# CITY OF ALBUQUERQUE

RE: **Heritage Marketplace Tract C3**  
**1720 Unser Blvd**  
**Conceptual Grading and Drainage Plan**  
**Engineer's Stamp Date 6/26/17 (File: H09D027)**

DATE: 8/11/2017	sheet: C1.1
SCALE: AS NOTED	of: 2

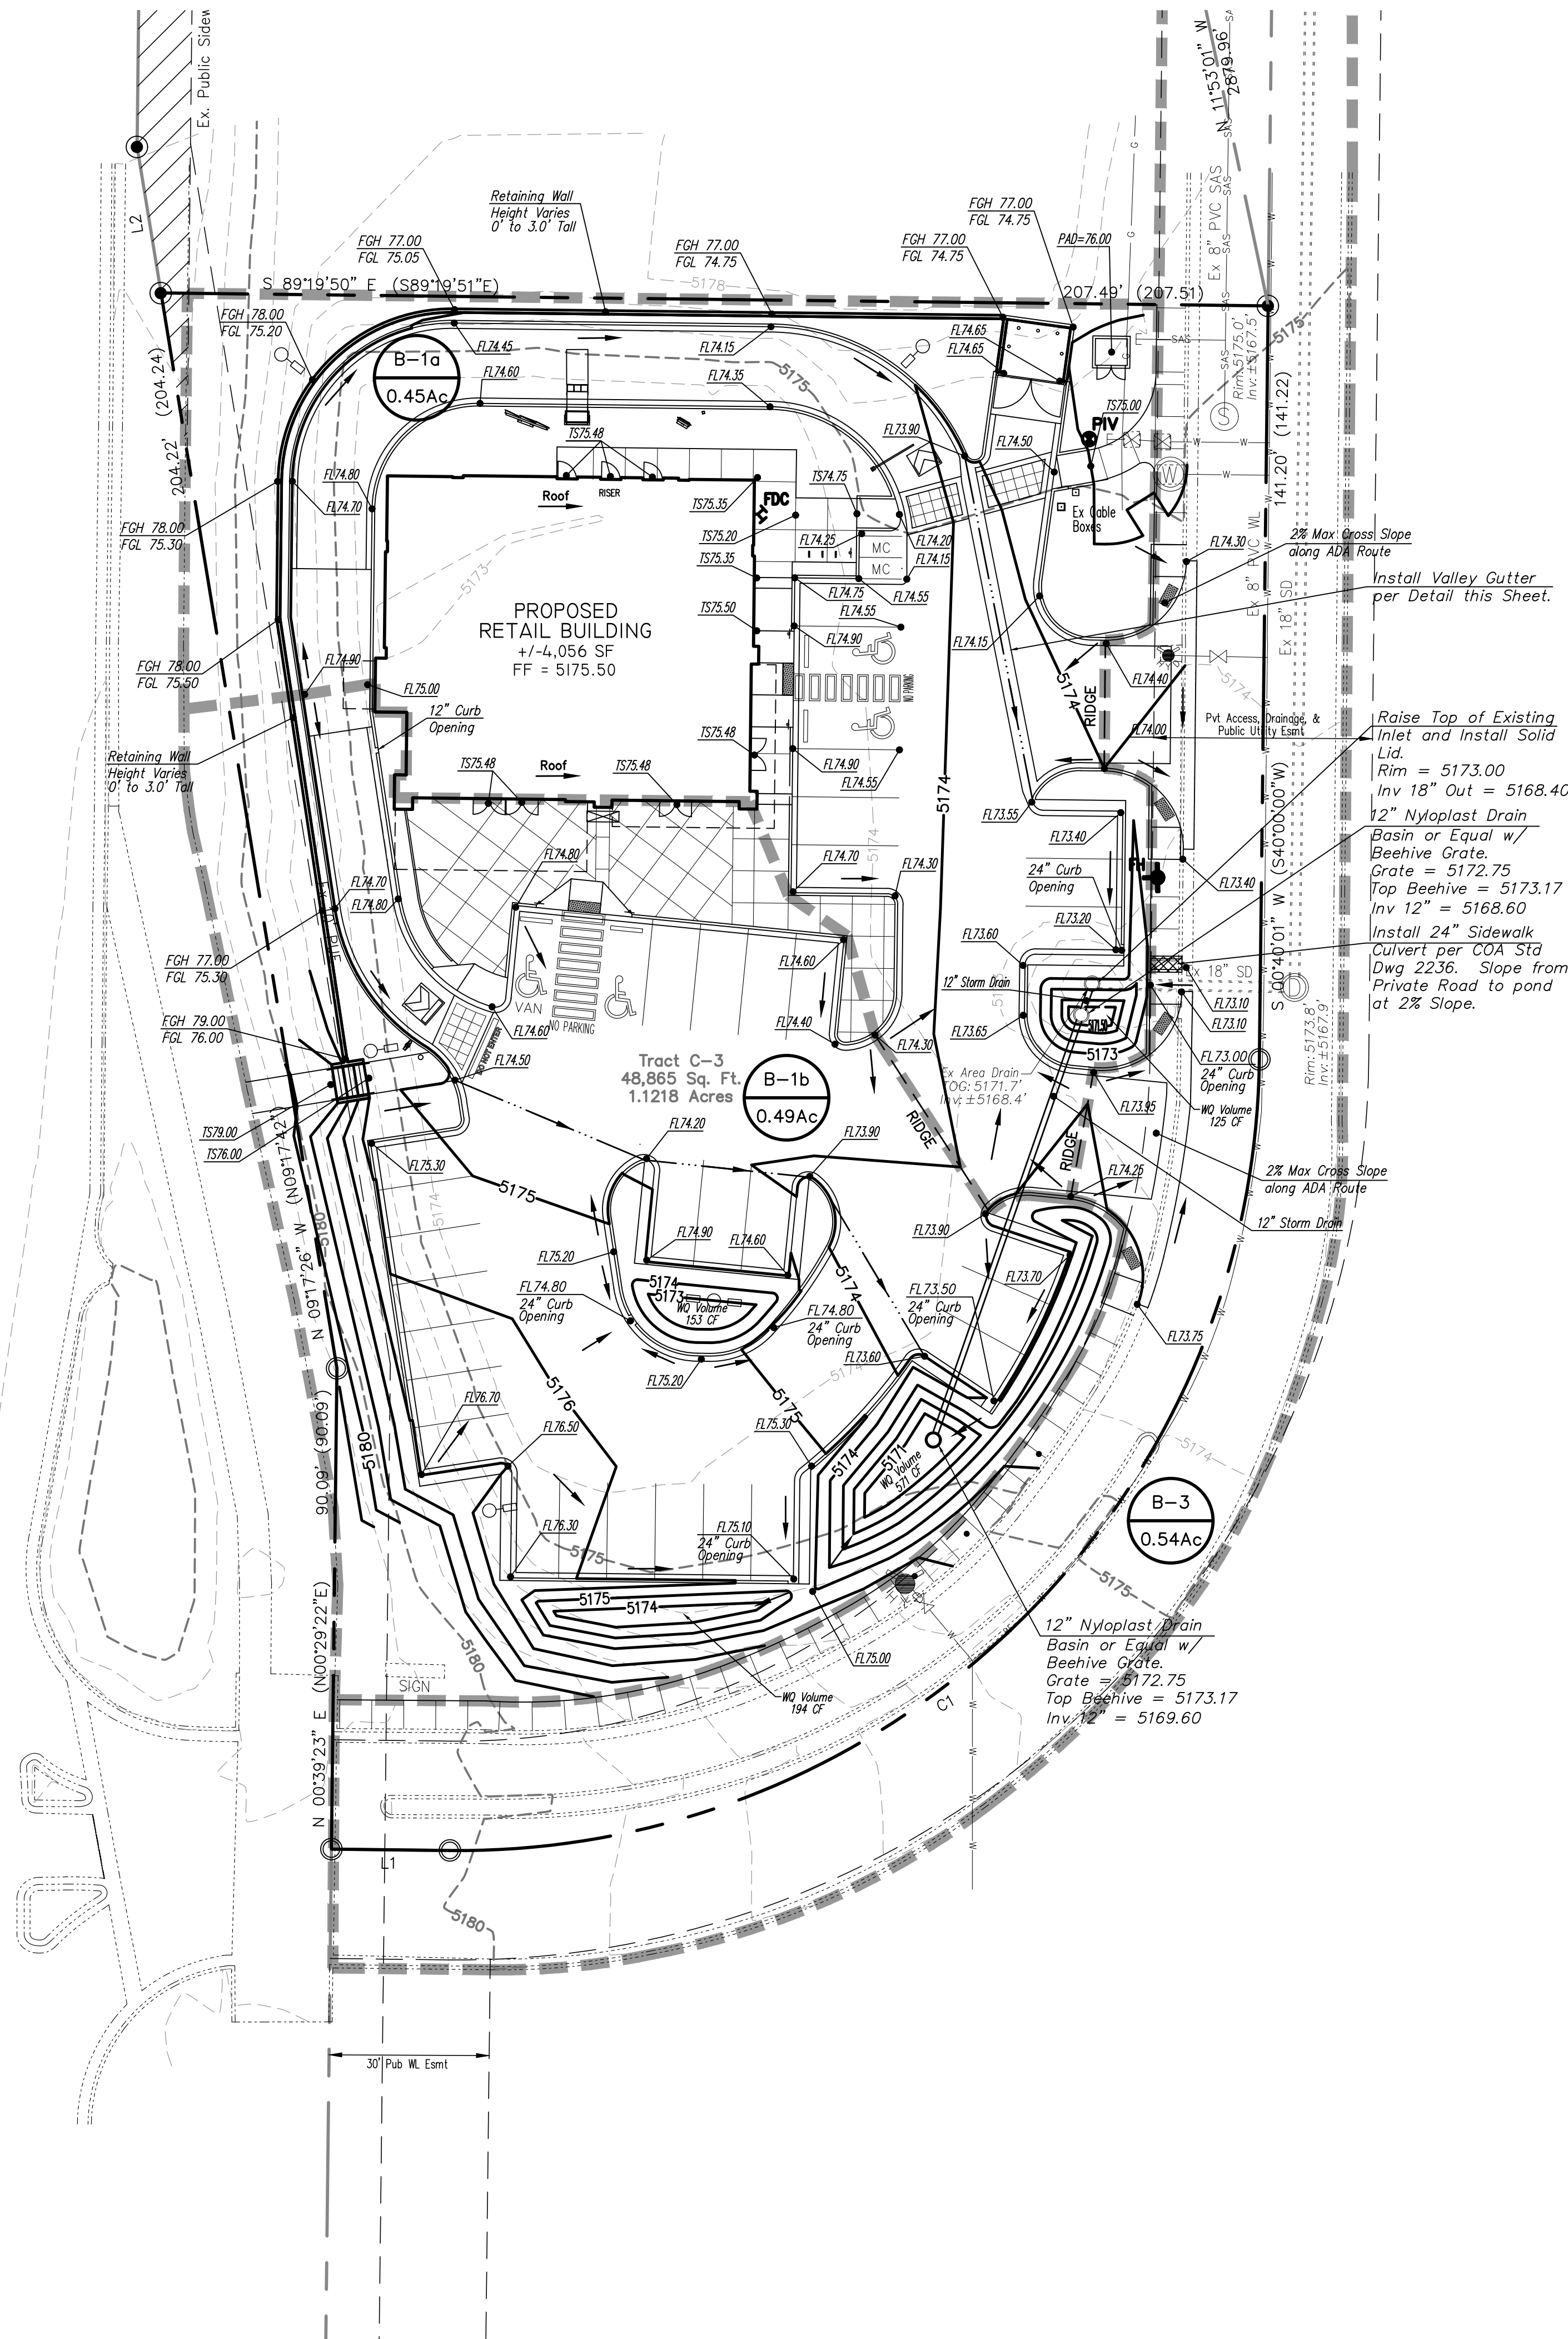
1. This work requires an Erosion and Sediment Control Plan to be submitted to the storm water quality engineer (Curtis Cherne, PE, [ccherne@cabq.gov](mailto:ccherne@cabq.gov)).
2. A private facility drainage covenant is required on the ponds.
3. According to the Heritage Marketplace Drainage Report, the entire development is allowed 2.4cfs/ac. However tract C-3 (referred to as Basin B-1 in the Drainage Report) is only allowed 2.1cfs in total. Other areas, such as roads are allowed to discharge greater amounts. Detention times and pond sizes will need to be increased to account for this.
4. The dumpster areas must be contained plumbed through a grease trap, and into the sanitary sewer. Include the utility plan if this information is located there.
